Orica Southlands Remediation and Redevelopment, Banksmeadow

Transport Assessment Review

July 2011

| STAGE 1 TRAFFIC IMPROVEMENT WORKS | | |

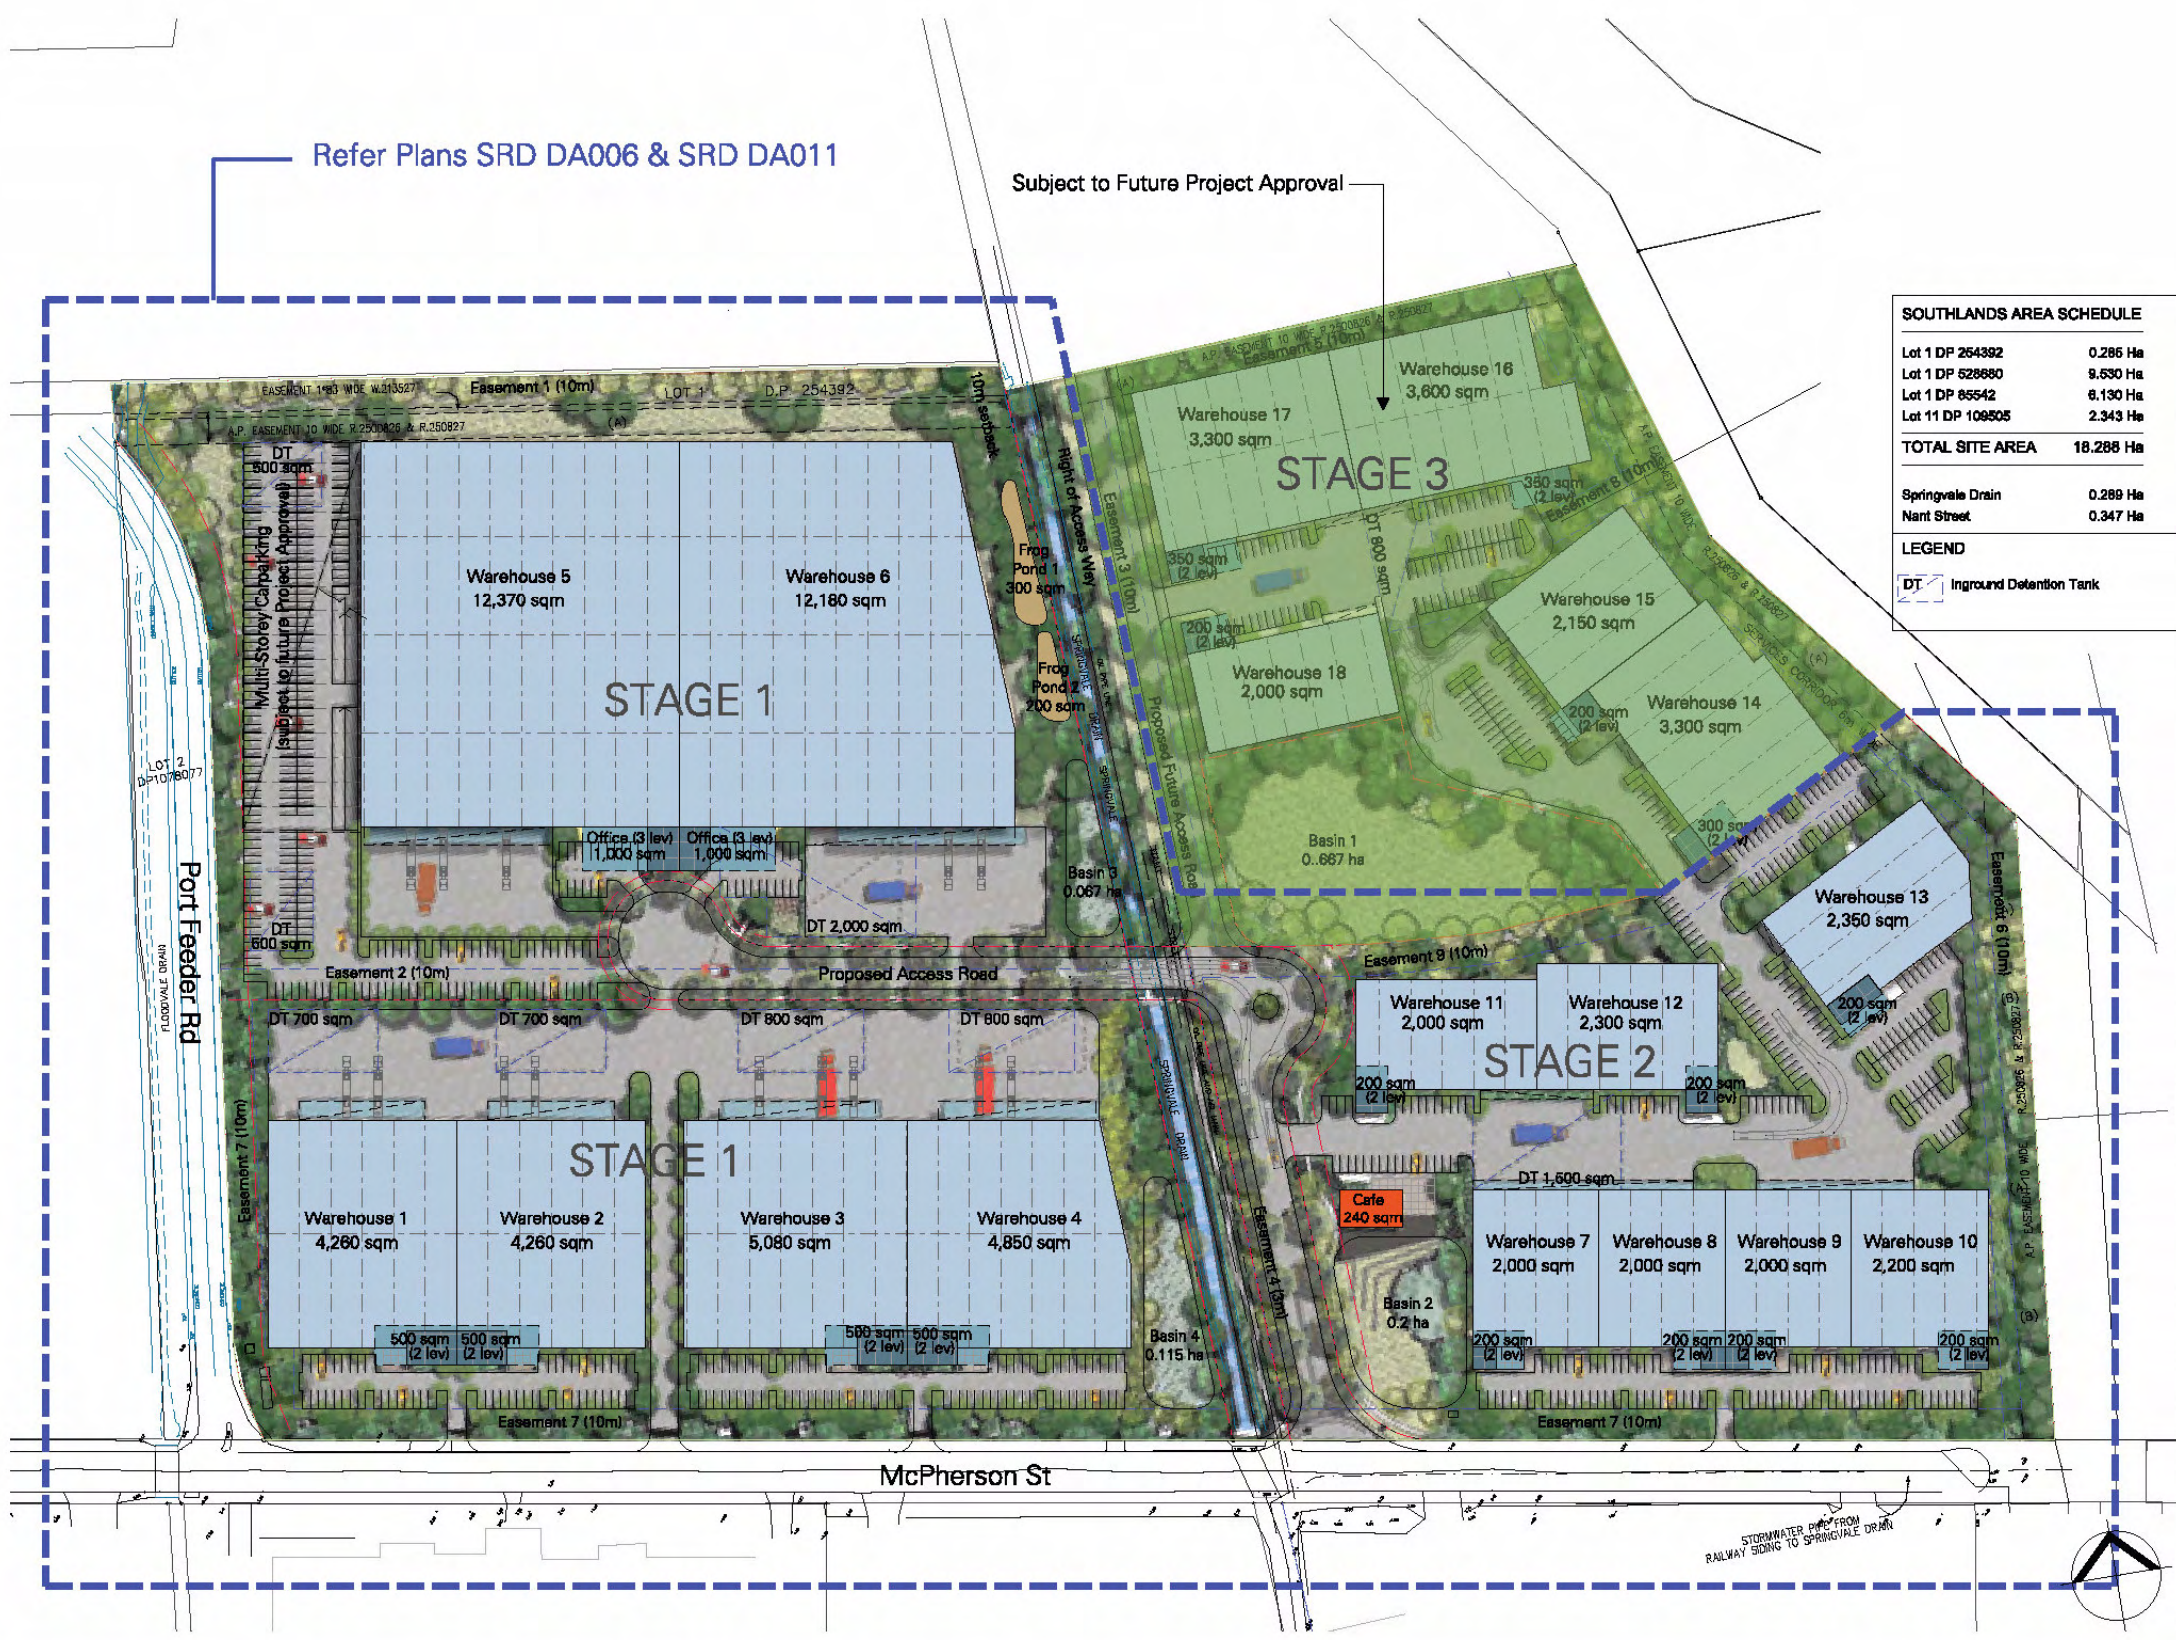
- For the proposed Hill Street intersection upgrade, there would be a circuitous route for vehicles wanting to access Greenfield Street from the left-turn off Botany Road southbound because of the restriction to cross-over movements in Hill Street. Vehicles would need to travel via Hill Street, McPherson Street, Exell Street and enter Greenfield Street westbound rather than enter directly eastbound from Hill Street. Moreover, vehicles would need to turnaround in Greenfield Street to exit via Exell Street rather than travel around the block again by exiting via Hill Street, McPherson Street and Exell Street to Botany Road. The assessment has not adequately addressed whether westbound Greenfield Street vehicles would be able to turn-around and exit via Exell Street.

- The deceleration lane for the left-turn into Hill Street from Botany Road would need to be sufficiently long and delineated to allow right-turn movements to safely assume that left-turn movements are not continuing southbound along Botany Road, thus unnecessarily delaying the right-turn movements into Hill Street.

- The proposed four-lane widening of the Botany Road southbound approach to Foreshore Road appears to encroach on adjacent land outside the existing road reserve. There is a risk that a larger road upgrade would be required, which would need to be approved by RTA and affect Foreshore Road / Botany Road / Penrhyn Road intersection operations.

- The Exell Street signalised intersection is located in relative close proximity to the Foreshore Road / Botany Road / Penrhyn Road intersection. Signal operations would need to be coordinated with the major intersection to prevent queuing upstream or downstream of the new intersection. Therefore, operations may not be optimal for traffic exiting Exell Street. This issue has been raised by RTA, which stated that signals would not be approved at this location because their modelling indicated extensive delays and unacceptable queue lengths on Botany Road.
